RE: North Bay at Lake Woodmoor, PUD Development Plan (PUDSP-16-004) 2nd Review Response

This letter responds to your January 4, 2018 review letter relating to the above referenced project. Responses to review comments are shown in **RED** below.

EL PASO COUNTY PLANNING AND COMMUNITY DEVELOPMENT DEPARTMENT

SITE PARKING CALCULATIONS

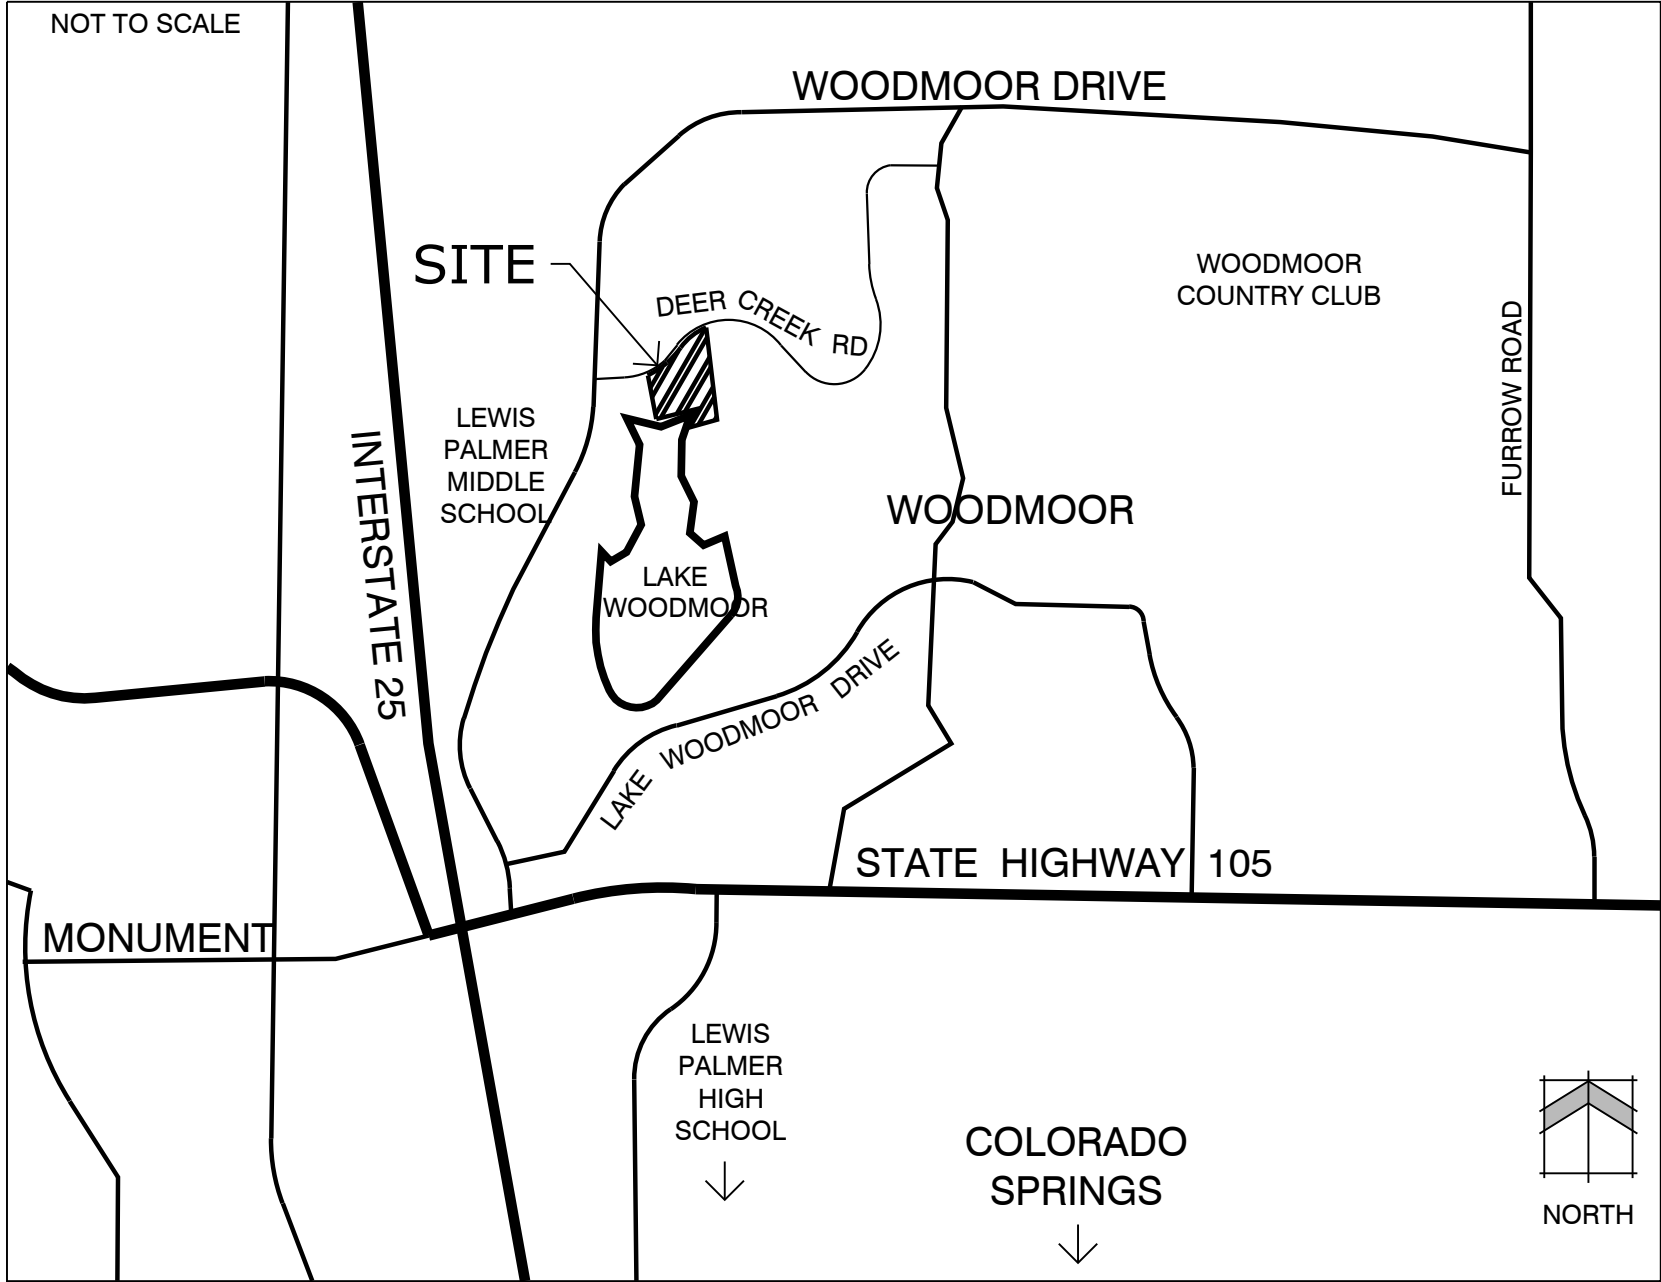
9. Include a parking table. **Addressed.**
10. Consider the adequacy of the proposed guest parking. Guest parking in townhome developments is absorbed quickly by guests and/or as tenants “third parking space”. **Previously addressed. There is sufficient parking to accommodate residents and guest parking. Each unit has a 2 car garage and the HOA covenants will require that these be kept available for parking. There are also 26 off-street parking bays and lots 15 and 16 have 2 car driveways, where only 10 guest parking spaces are required by Code.**

PUD SP - 16 - 004

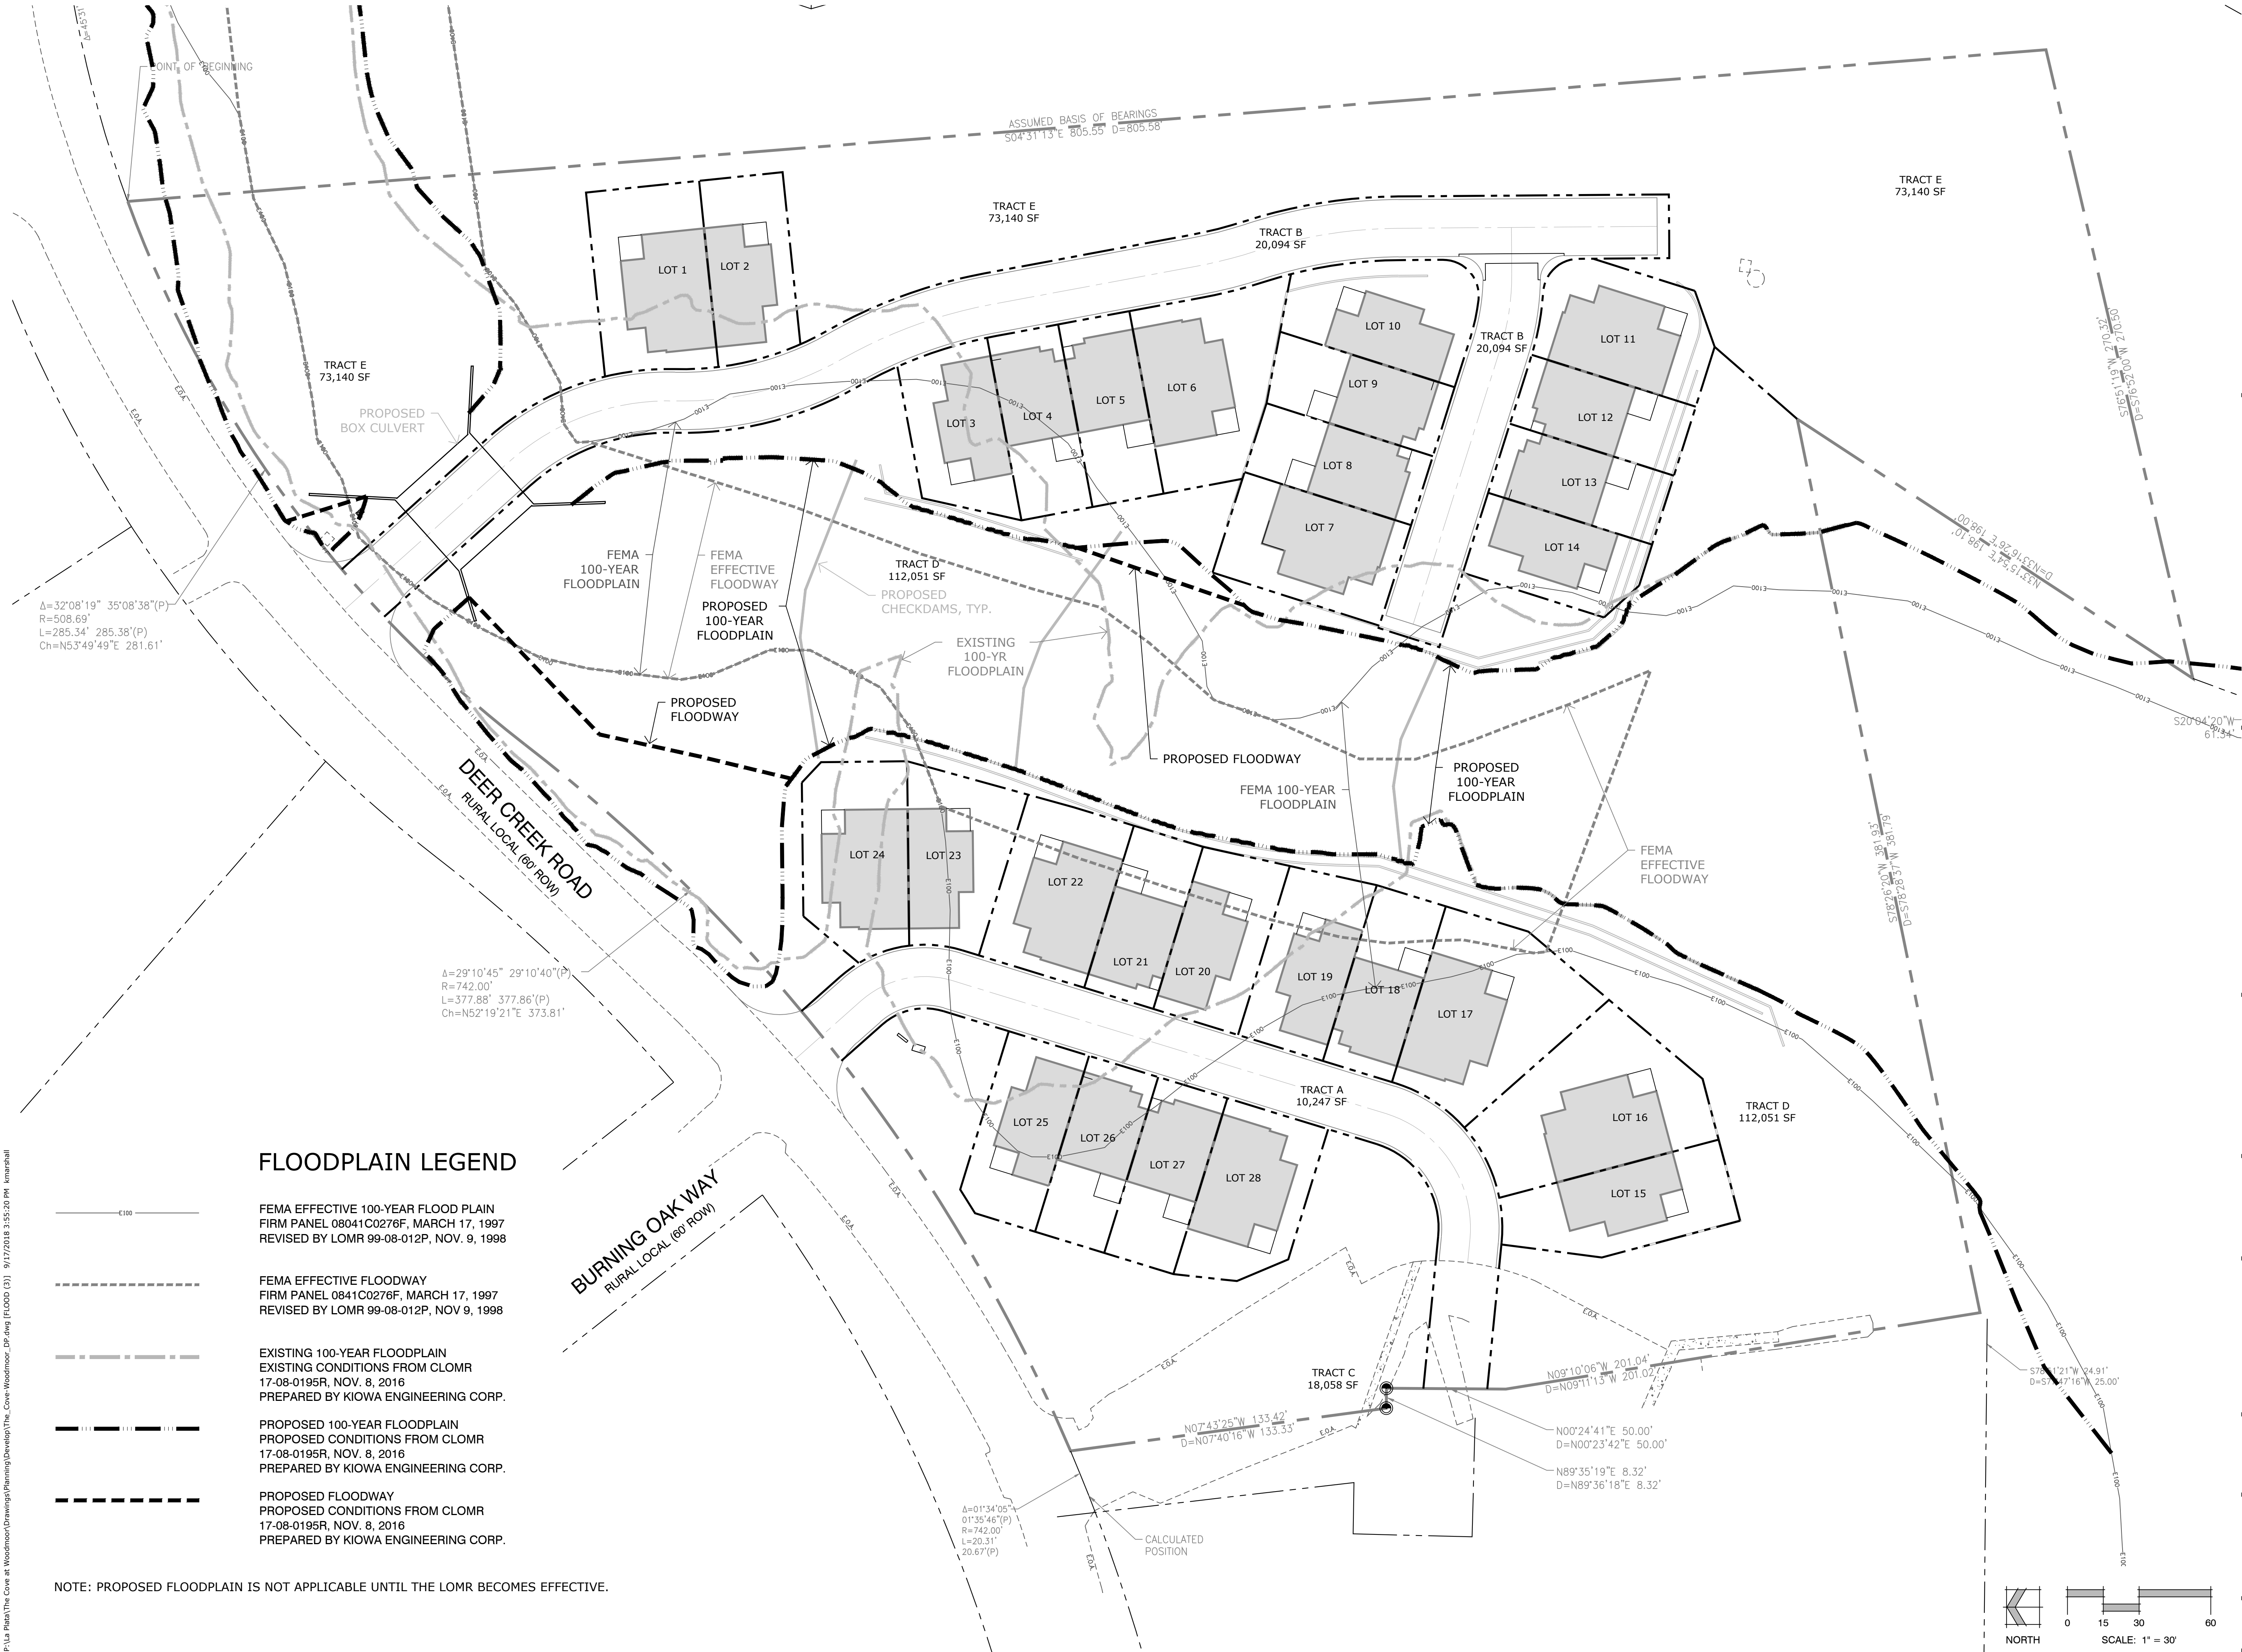
4. Addressed.
5. Addressed but the line types are difficult to read. Consider new line types to clearly define the existing and proposed floodplain. **Addressed.**

6. Addressed. Tract E and D do not have a separating lot line shown. **Addressed.**
7. Addressed.
8. Addressed. Please also remove existing trees/shrubs from the sign triangle. **Addressed.**

**FLOODPLAIN AND  
FLOODWAY  
EXHIBIT**

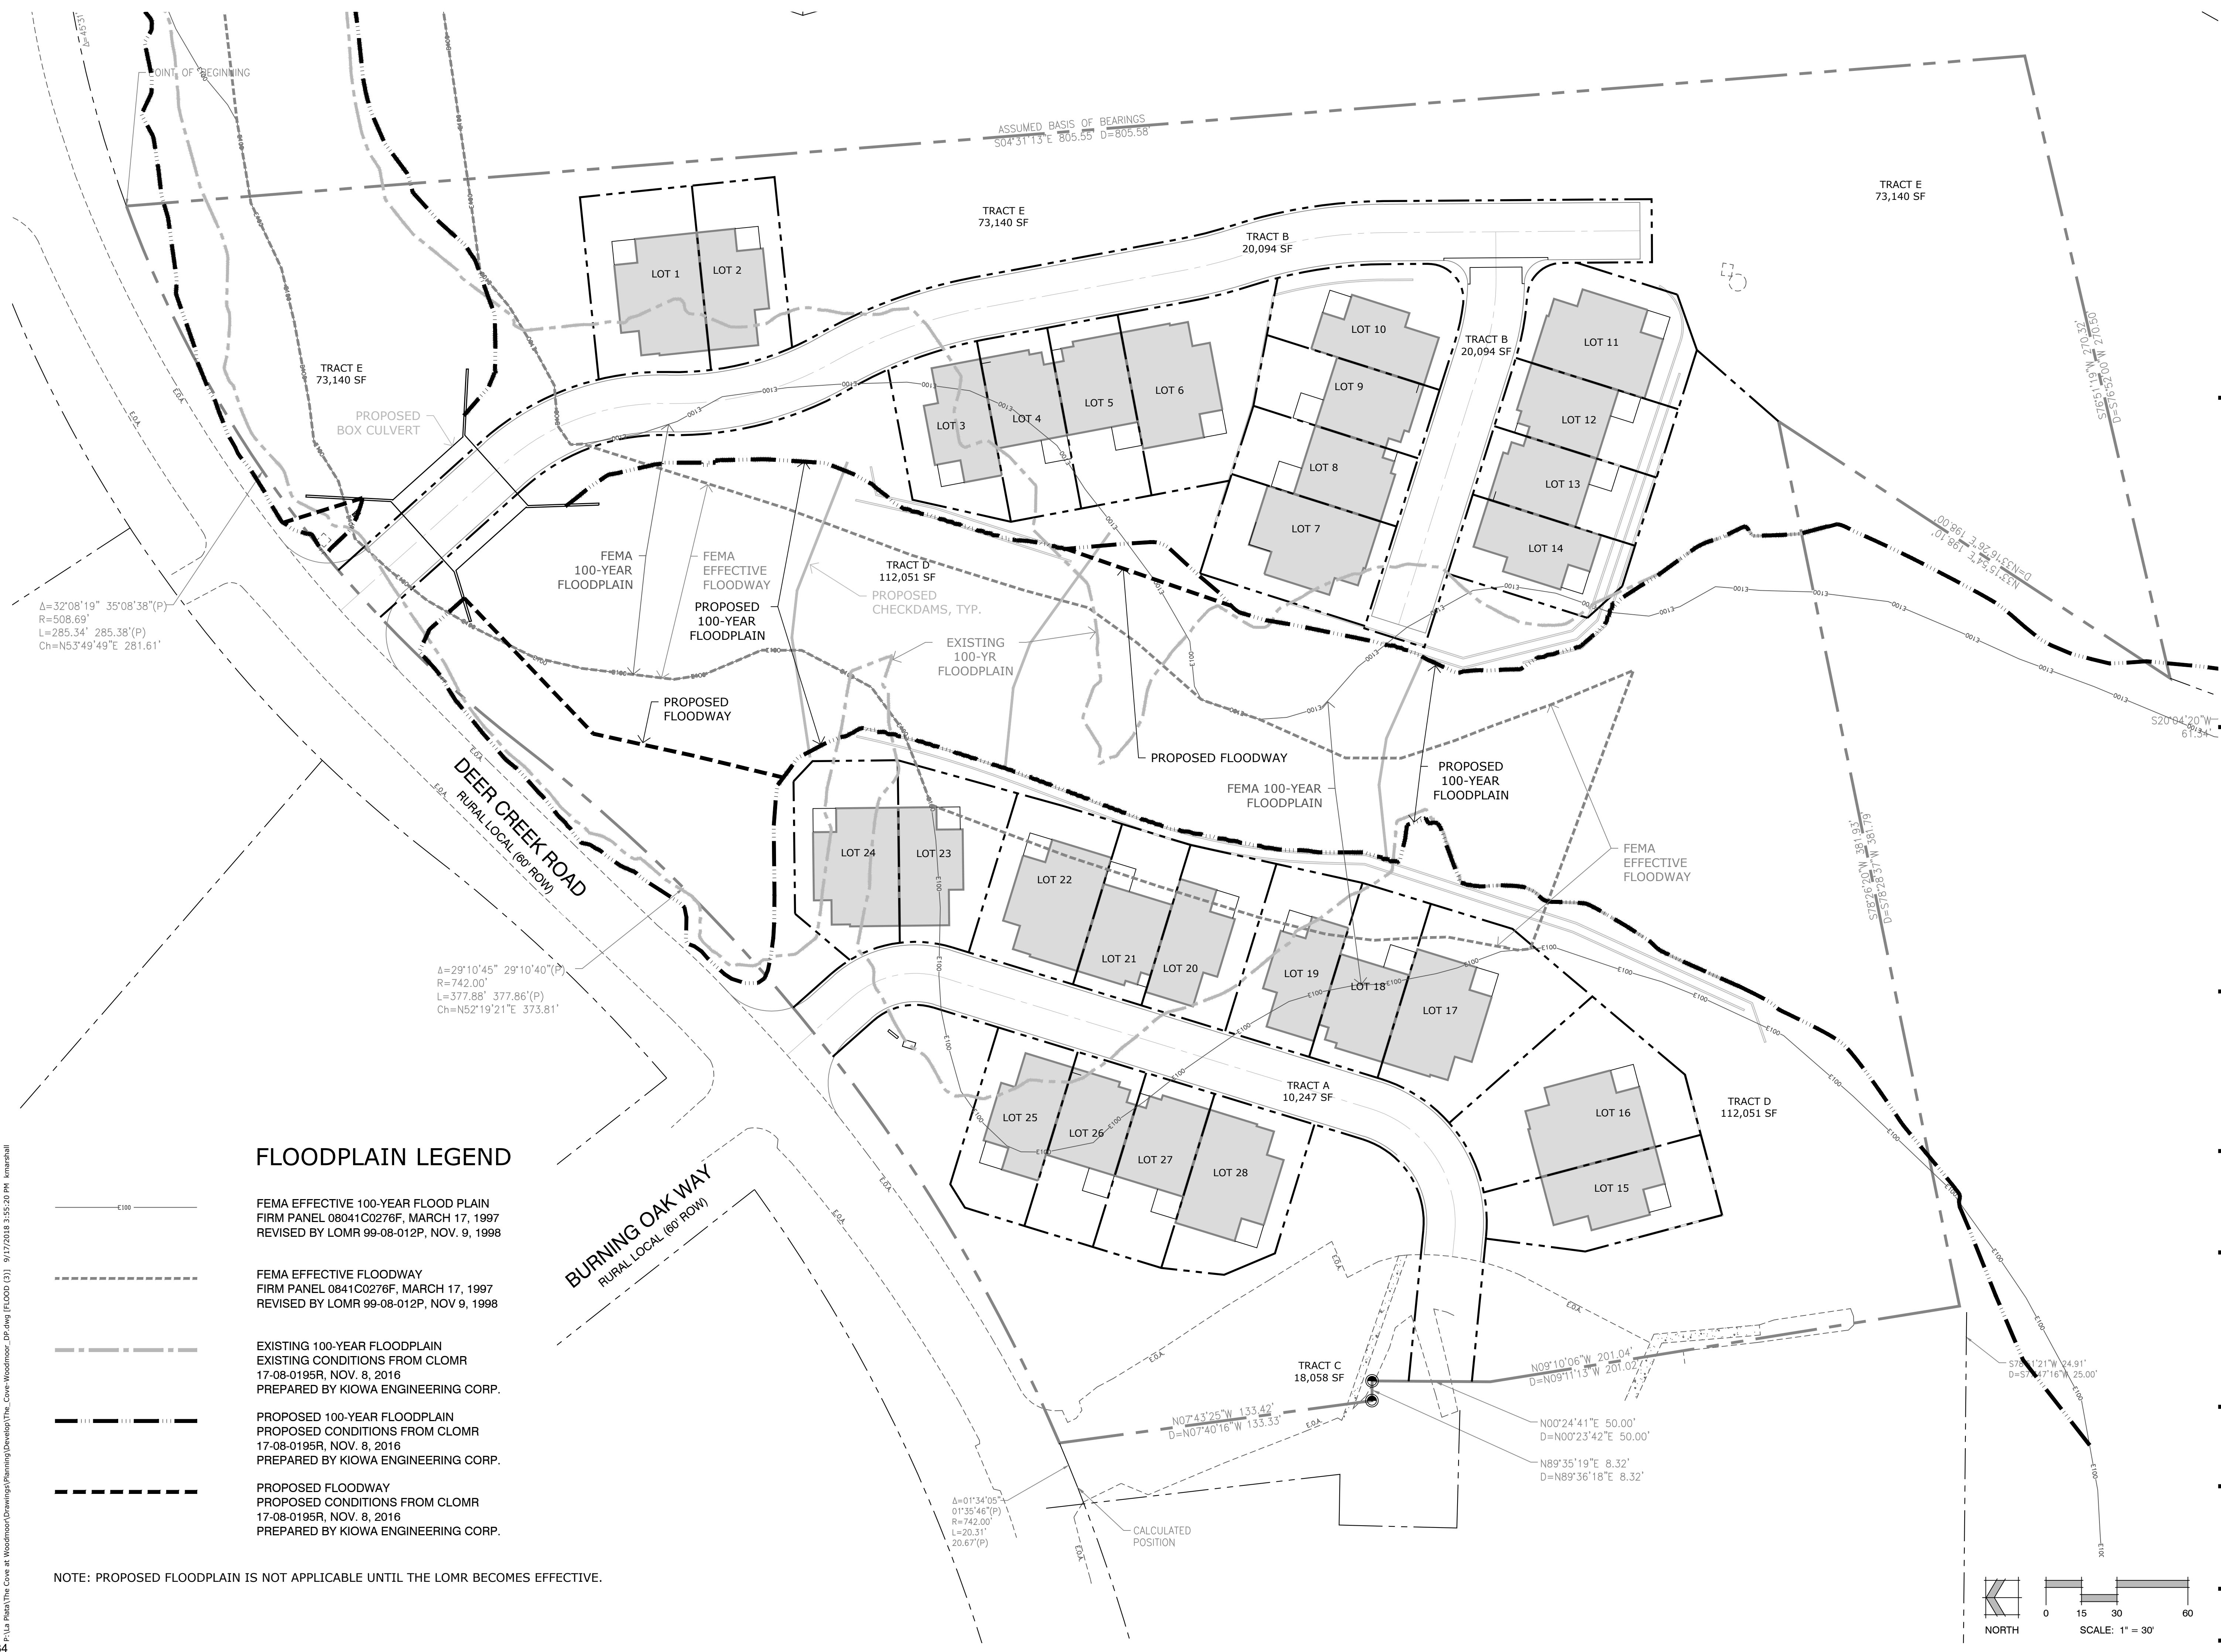
1. Resolved.
2. Add a note stating the proposed floodway is not applicable until the LOMR becomes effective. **Change the text from CLOMR to LOMR. Addressed**
3. Resolved.
4. Per ECM Table 2-5 the minimum intersection spacing is 330 ft. Adjust the layout to meet criteria or submit a deviation request. **Pending. Deviation request was not in the resubmittal. Deviation request was previously submitted and is submitted again.**
5. Resolved.
6. Resolved.
7. Resolved.
